**Integra Underground  
Post Approval Review**

Document: Integra Underground Air Quality and Greenhouse Gas Management Plan

Revision: Version 5.1, Dated 26 July 2019 – 26 July 2022

Reviewed: Sarah Clibborn on 26 November 2020

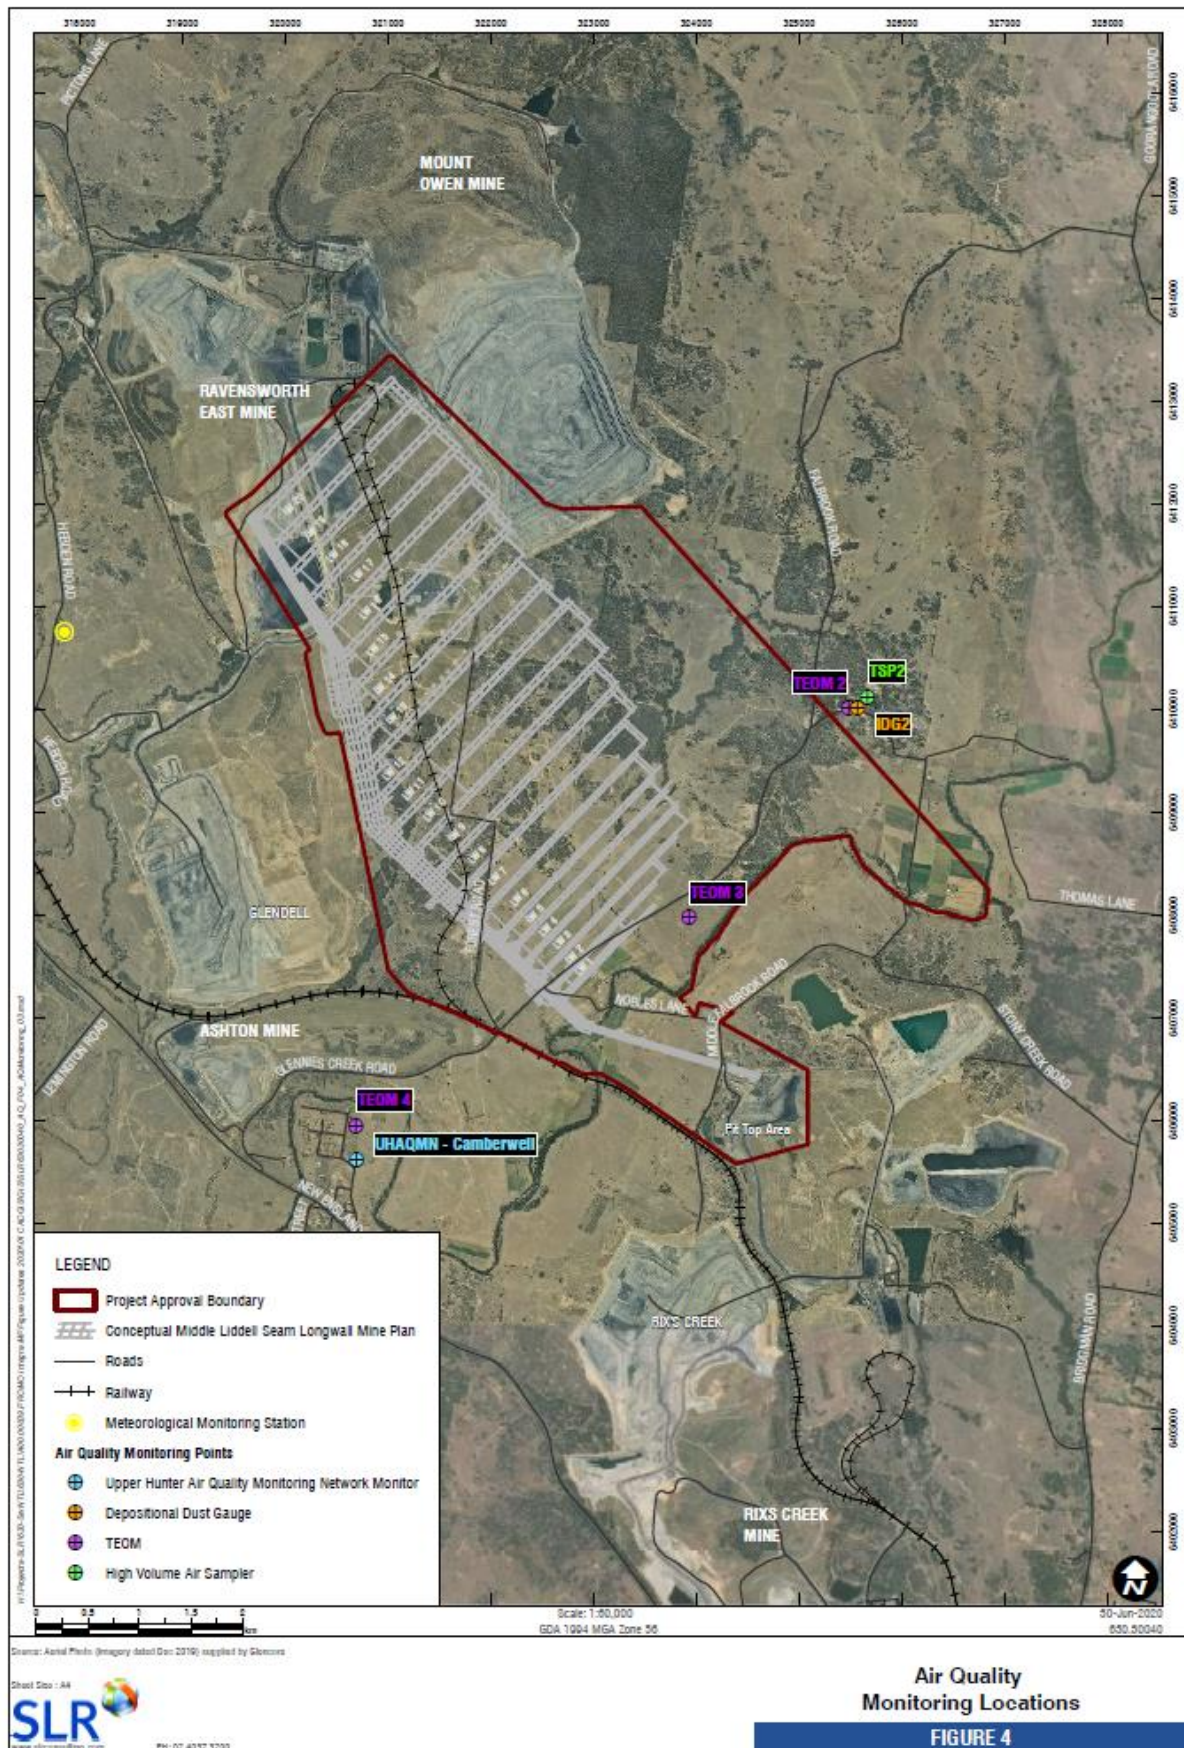
<p>Department considers that one Deposited Dust Gauge is not adequate to evaluate the performance of the project.</p> <p>The Department acknowledges that there is potential duplication of results between IDG4, IDG5, IDG6 and IDG7. The Department also acknowledges that there is potential duplication of results between IDG1 and IDG2, and that IDG2 is more representative of sensitive receptors. The Department is supportive of the rationalisation of Integra UG's Deposited Dust Gauges to improve the efficiency of sample collection, however, strongly recommends that more than one Deposited Dust Gauge be retained.</p>	network accordingly.	<p>gauge to be adequate to meet the requirements of PA 08_0101. Notwithstanding, Integra Underground has taken the Department's review comments are presents a monitoring program that includes three gauges. The following have been updated to reflect this: Section 4.1, Figure 4, Table 4-1</p>
